CITY OF ALBUQUERQUE

PLANNING DEPARTMENT – Development Review Services

June 28, 2016

RE: Cuatro Development – 1319 4th St. NW (File: J14D173)
Grading & Drainage Plan, Engineer's Stamp Date 11-17-2014
Engineer's Certification Date 6-23-16

FILE:	DRAINAGE AND GRADING PLAN CUATRO DEVELOPMENT-SOUTH HALF	DATE/REVISIONS:
	APPLIED ENGINEERING AND SURVEYING, INC. ENGINEERS AND PLANNERS 1800 Blvd. Santa Fe Office: (505) 425-0125 gpatrick@ayps.com	SHEET NUMBER: CIVIL105 3 OF 4

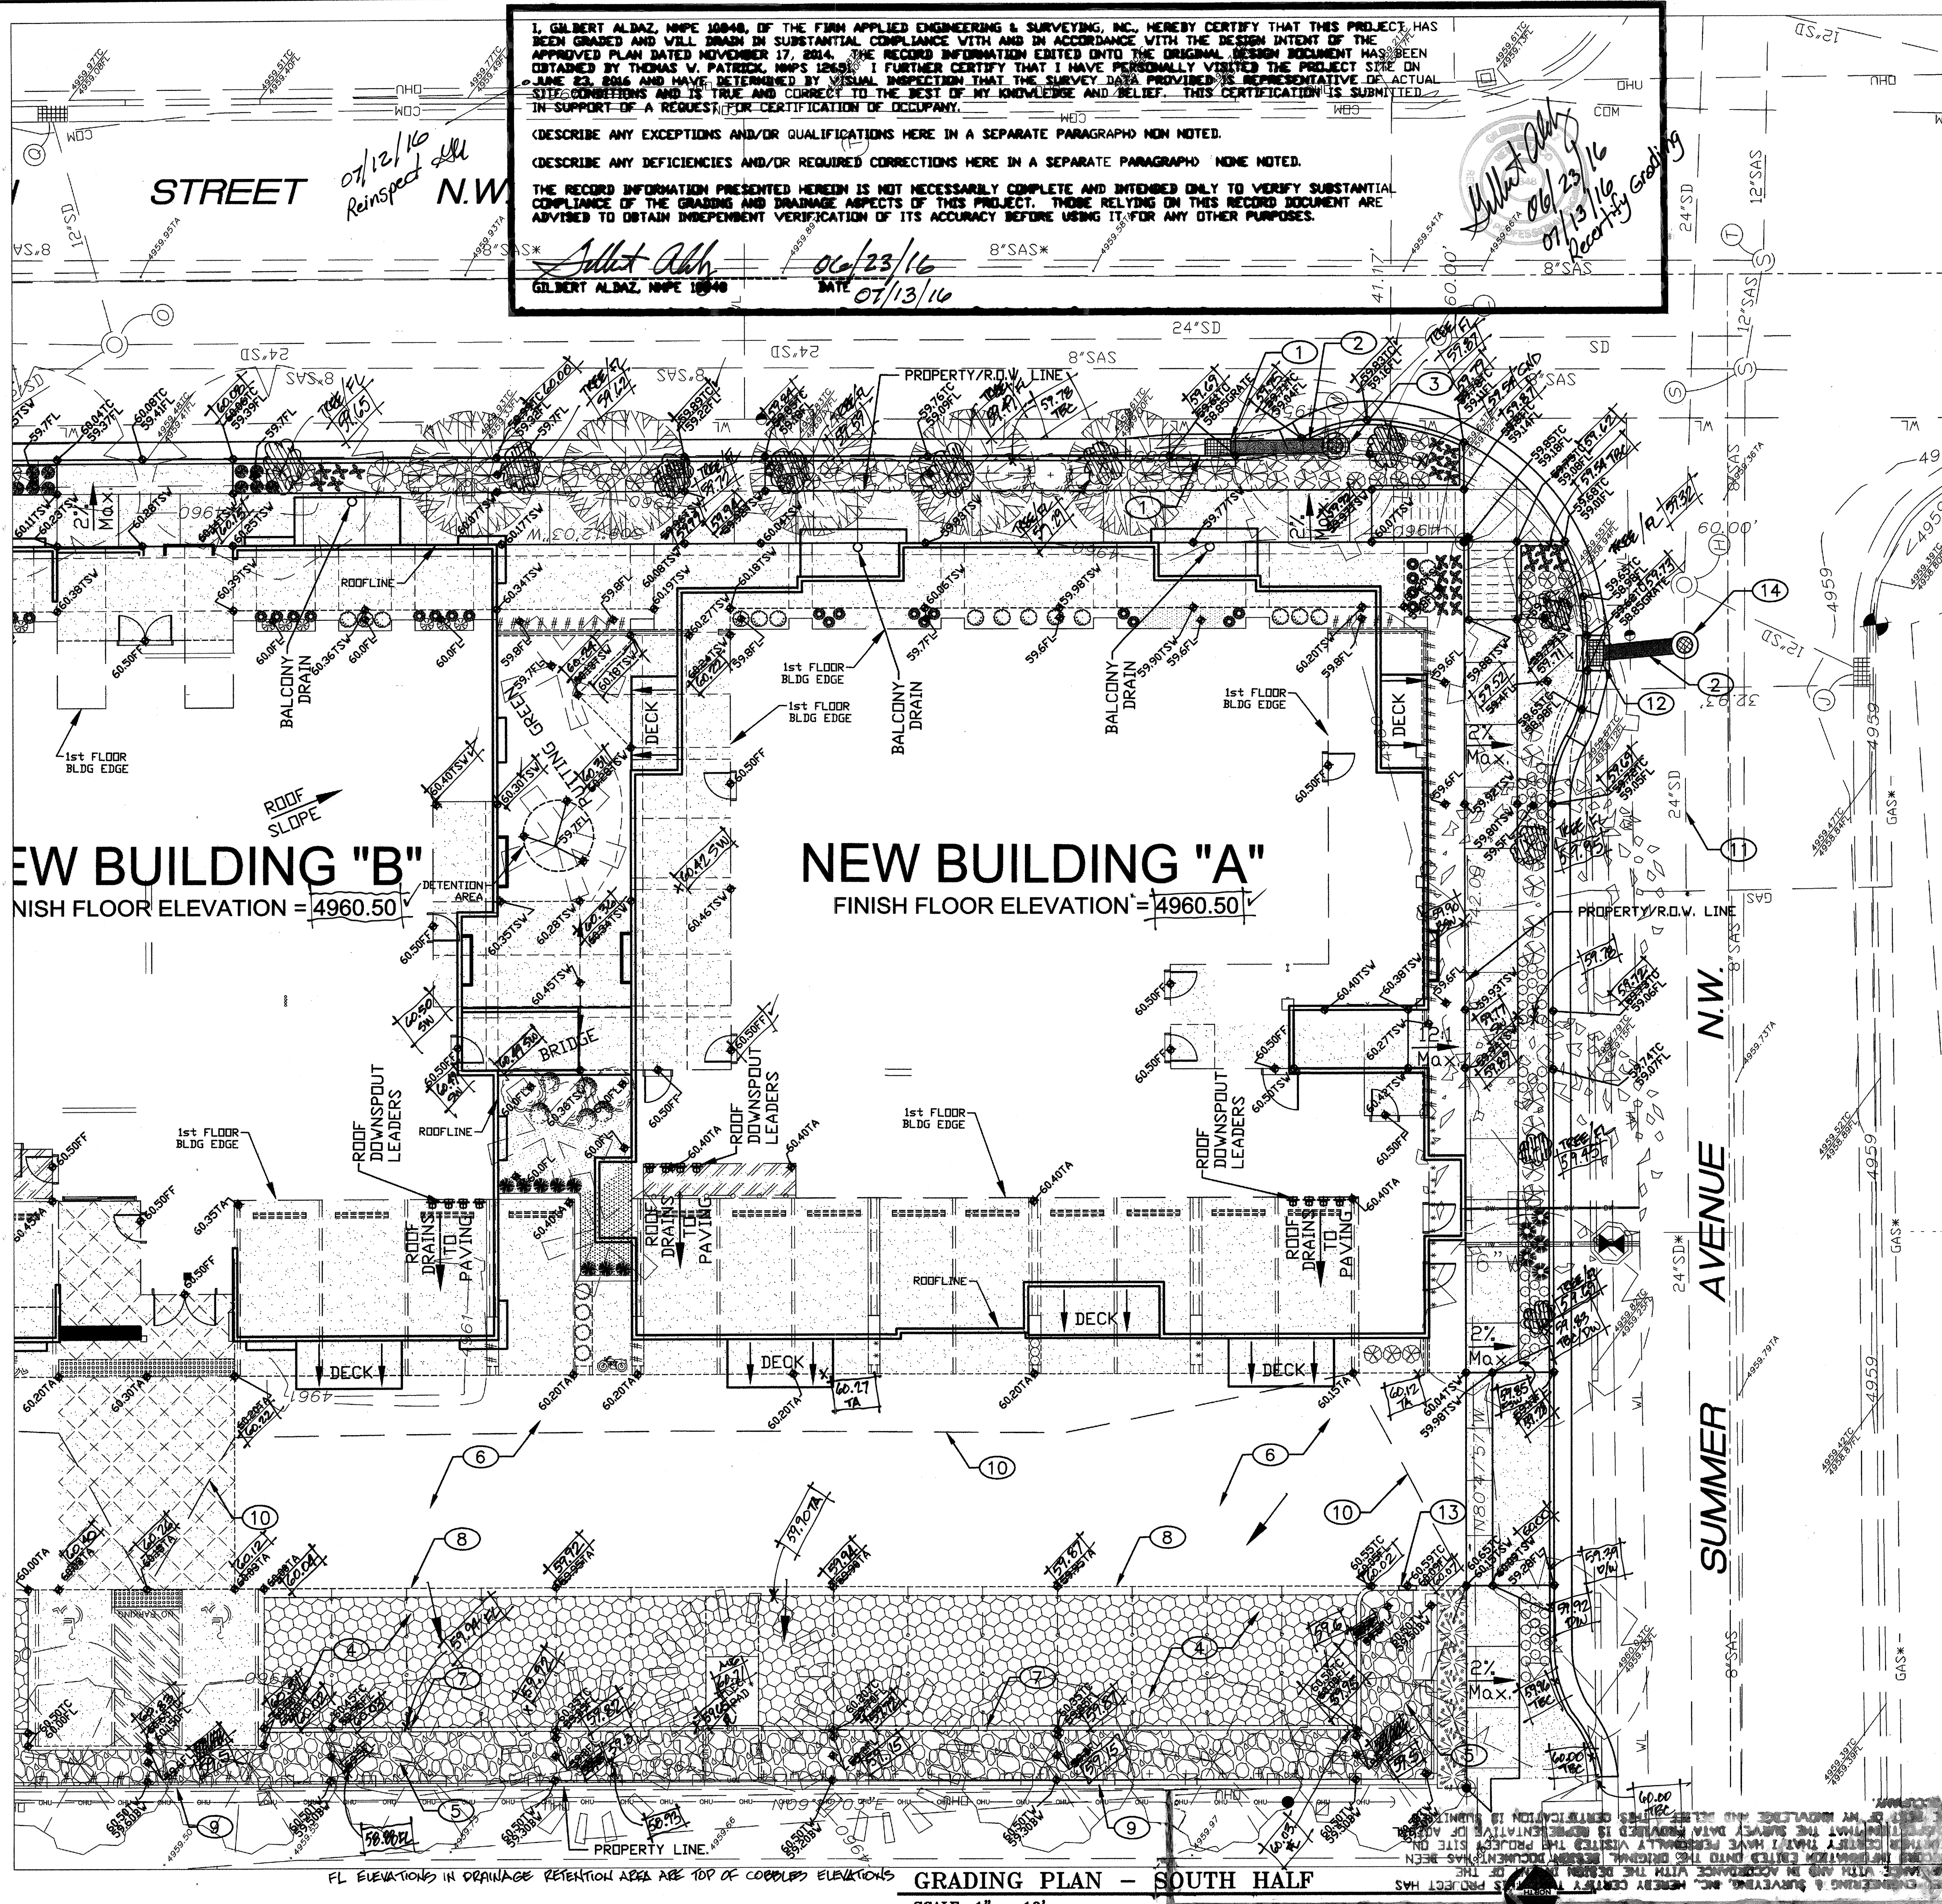
- Area with Geogrid system is to drain into channel along western boundary. The curb cuts are not deep enough, and the channel is filled with cobble. Per the Grading and drainage plan, the cobble should be approximately 8" – 12" below the top of curb. To rectify the problem, the following fixes are recommended:

- Core drill holes in the curb, just above the Geogrid
 - Between the landscaping bushes in the channel, lower the top of rip-rap /cobble to about 14"-18" below the top of curb. The increase in depth is to compensate for the volume taken up by the landscaping bushes. Water should be able to flow from low spot to low spot between the bushes.

- In parking area, the infill material of the Geogrid system is extremely unstable and must be stabilized. Per the specs, a well – graded material was recommended (see snapshot below). Mixing in crusher fines, angular rock, and smaller diameter rock to improve gradation is recommended.
